Date: 29/11/2019

Our Ref: R/2017/28/B
File No: 2019/602990

Response to Submissions – State Significant Development SSD 8993 – SCEGGS Darlinghurst concept approval of the 2040 Masterplan and Stage 1 works

Drawing Title
**ENVELOPES DIMENSIONS
LEVEL 2**

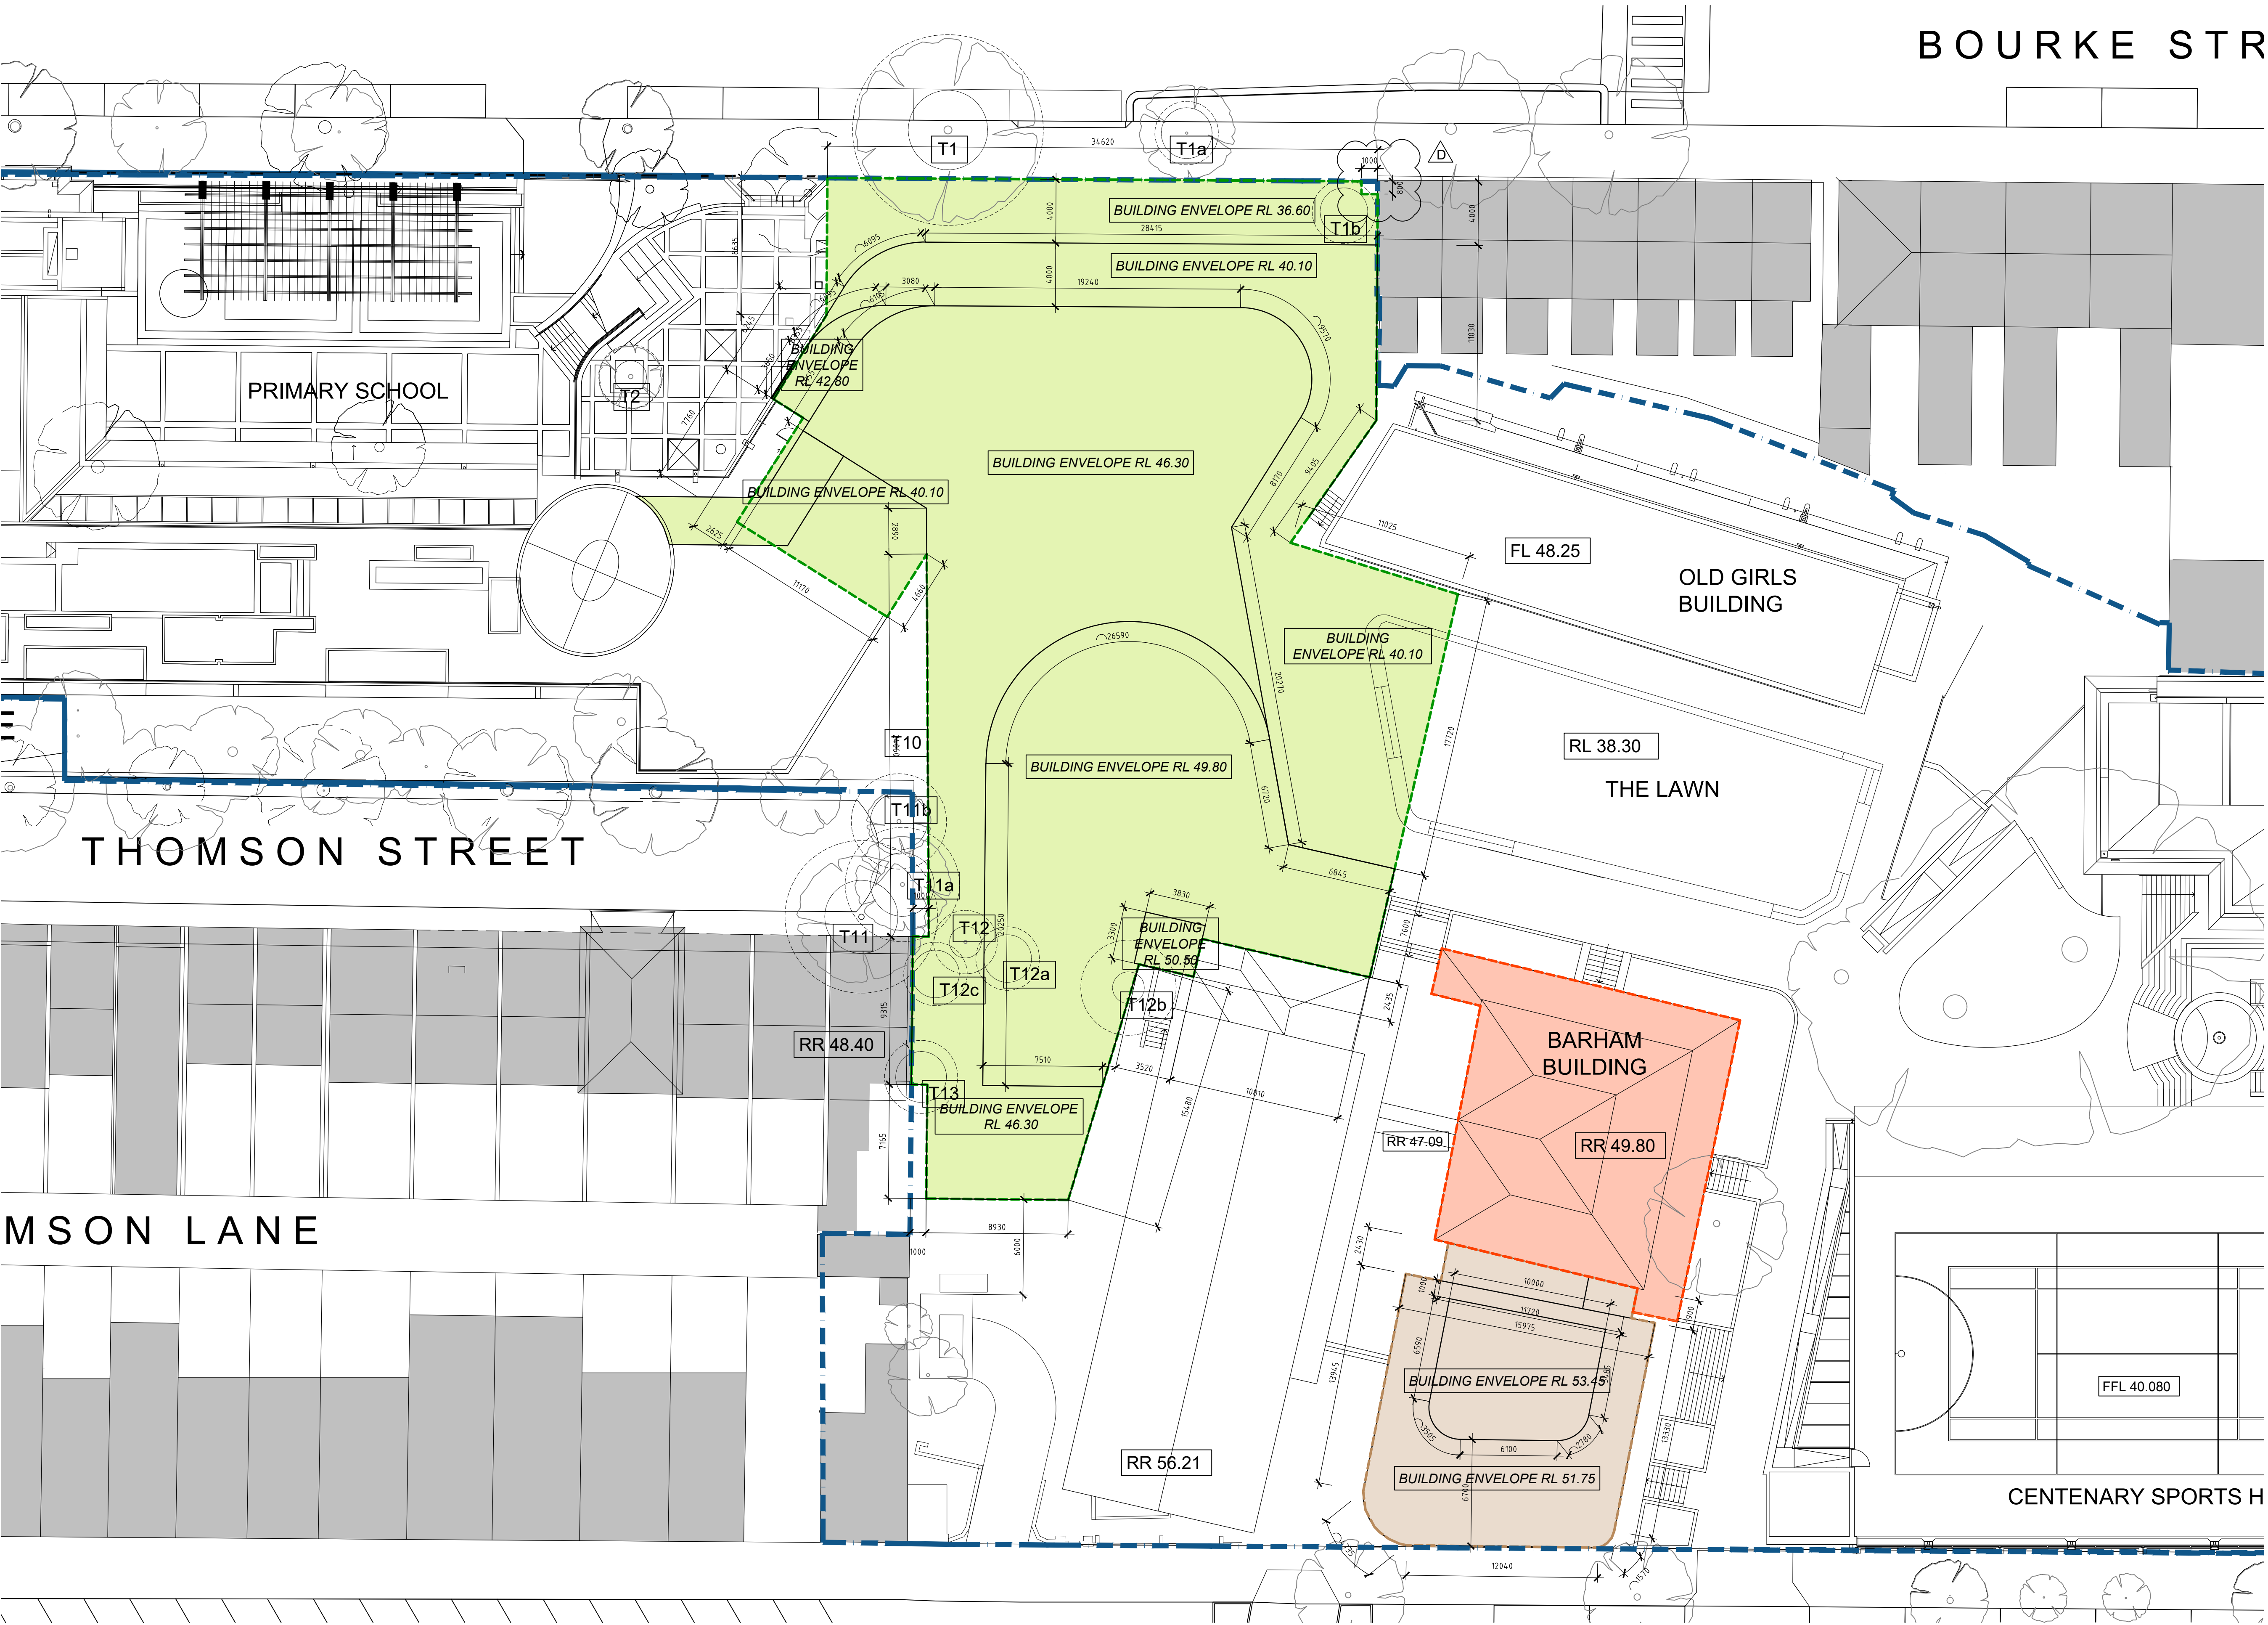
The recess shown in the detailed drawings (eg AR.MP.6003) between the heritage terraces and the proposed two storey street wall is not reflected in the proposed building envelope. The envelope should reflect the plans with the depth of the recess to be at least 1 metre from the face of the proposed new building to Bourke Street. The height of this indented recess is to also be amended in the envelope to reflect the detailed architectural drawings.

ELEVATION CC - BOURKE STREET

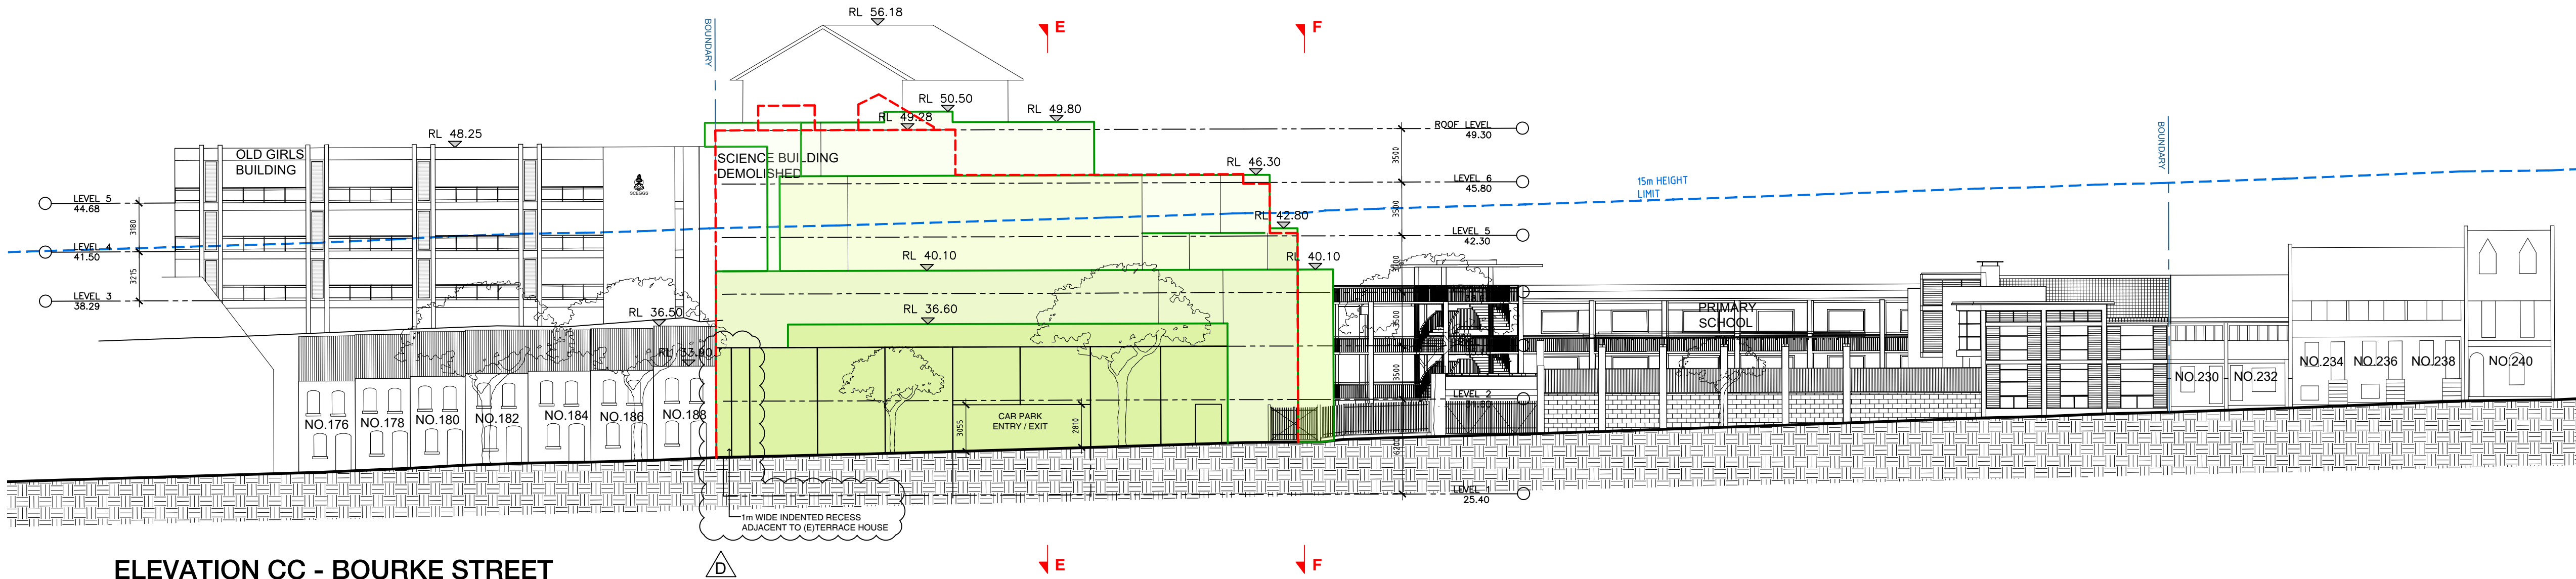
The City acknowledges and is generally supportive of the reductions to the building envelope fronting Bourke Street. However, the envelope should be amended such that the street wall height matches the adjacent terraces, and the level above is setback with no protrusions beyond the ridgeline of the terraces.
